# CITY OF ALBUQUERQUE

November 18, 2019

**Re: Albuquerque Central Care Center**  
**621 Columbia Dr SE**  
**Traffic Circulation Layout**  
Engineer's/Architect's Stamp 10-07-2019 (L16D042)

1 SITE PLAN-TCL
1" = 20'-0"

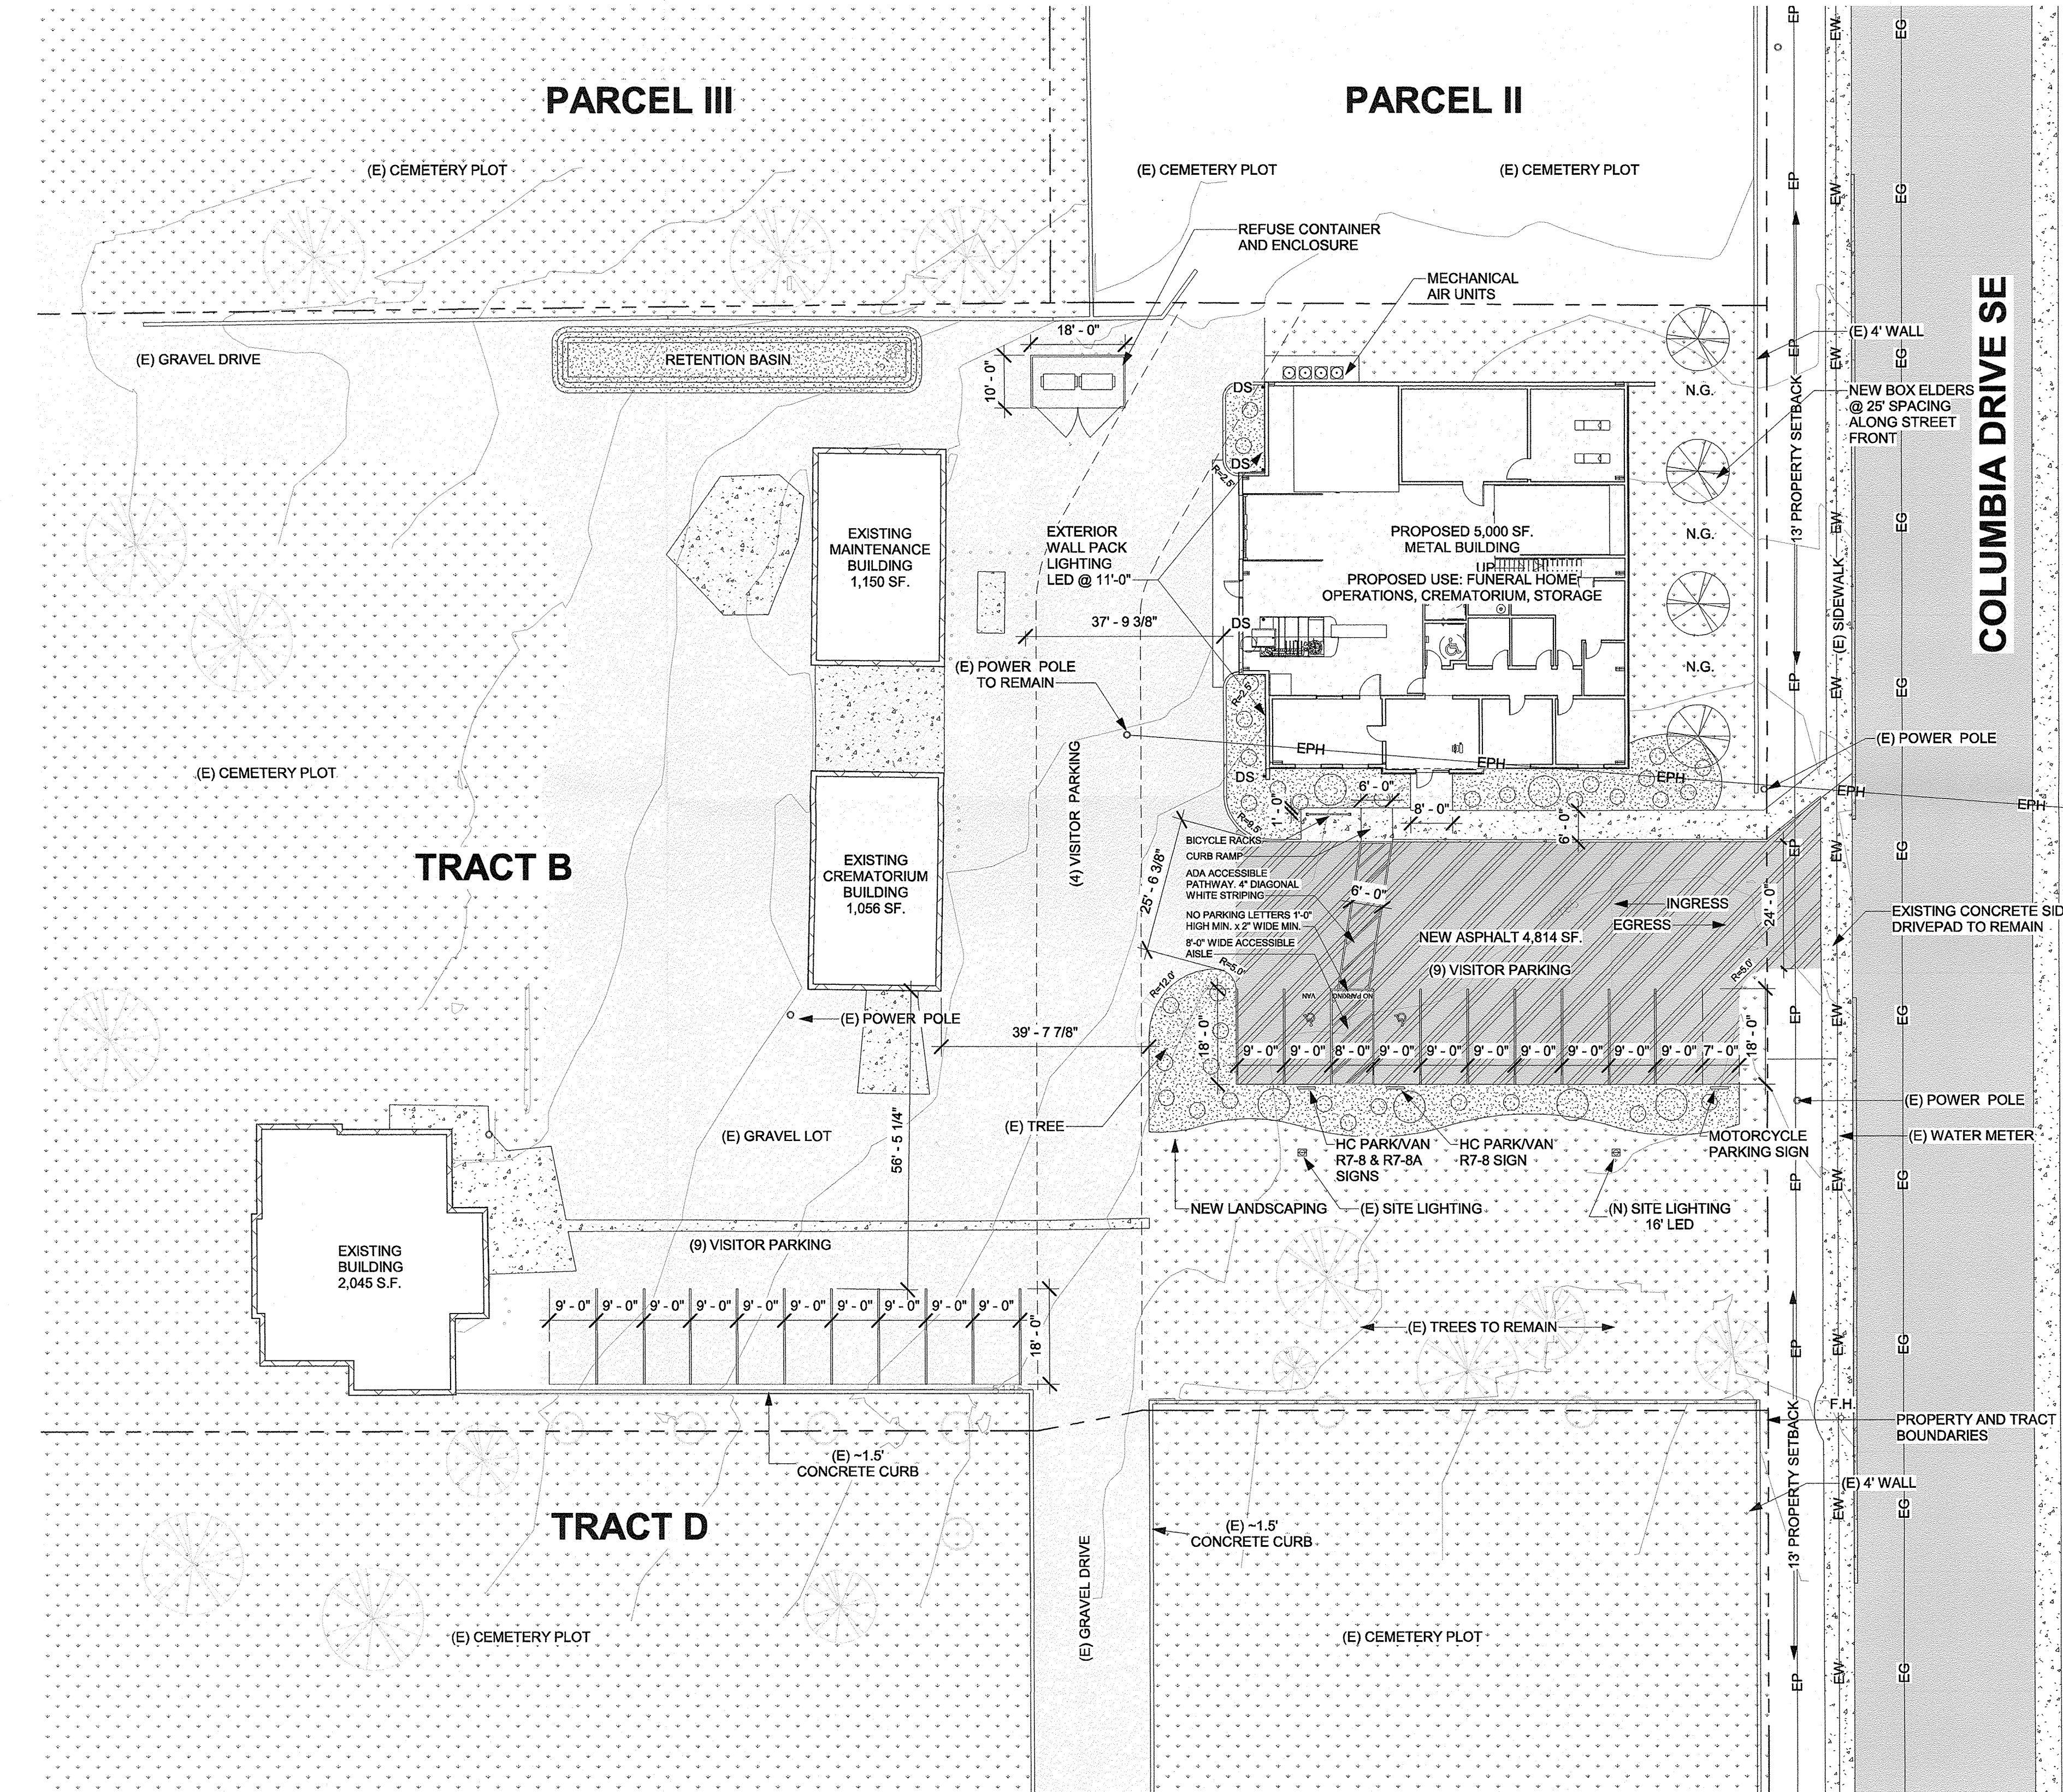
1. Please list the width and length for all existing and proposed parking spaces. Some dimensions are not shown.
2. The ADA accessible spaces must include an access aisle. Van accessible aisles should be 8ft wide; all others should be 5ft wide.

3. The ADA accessible parking sign must have the required language per 66-7-352.4C NMSA 1978 **"Violators Are Subject to a Fine and/or Towing."** Please call out detail and location of signs.

4. The ADA access aisles shall have the words **"NO PARKING"** in capital letters, each of which shall be at least one foot high and at least two inches wide, placed at the rear of the parking space so as to be close to where an adjacent vehicle's rear tire would be placed. (66-1-4.1.B NMSA 1978)

5. Motorcycle parking spaces shall be designated by its own conspicuously posted upright sign, either free-standing or wall mounted per the zoning code.

6. All bicycle racks shall be designed according to the following guidelines:
  - a. The rack shall be a minimum 30 inches tall and 18 inches wide.
  - b. The bicycle frame shall be supported horizontally at two or more places. Comb/toaster racks are not allowed.

- c. The rack shall be designed to support the bicycle in an upright position. See the IDO for additional information.
  - d. The rack allows varying bicycle frame sizes and styles to be attached.

- e. The user is not required to lift the bicycle onto the bicycle rack.
  - f. Each bicycle parking space is accessible without moving another bicycle.

7. Bicycle racks shall be sturdy and anchored to a concrete pad.

8. A 1-foot clear zone around the bicycle parking stall shall be provided.
9. Bicycle parking spaces shall be at least 6 feet long and 2 feet wide.
10. Show all drive aisle widths and radii. Some dimensions are not shown.

11. Per DPM, a 6 ft. wide ADA accessible pedestrian pathway is required from the ADA parking stall access aisles to the building entrances. Please clearly show this pathway and provide details.

12. Refuse vehicle maneuvering shall be contained on-site. The refuse vehicle shall not back into the public right of way.; **provide a copy of refuse approval.**

13. Unused curb cuts must be replaced with sidewalk and curb & gutter. A build note must be provided referring to the appropriate City Standard drawing.

14. Add a note stating "All broken or cracked sidewalk must be replaced with sidewalk and curb & gutter." A build note must be provided referring to the appropriate City Standard drawing.
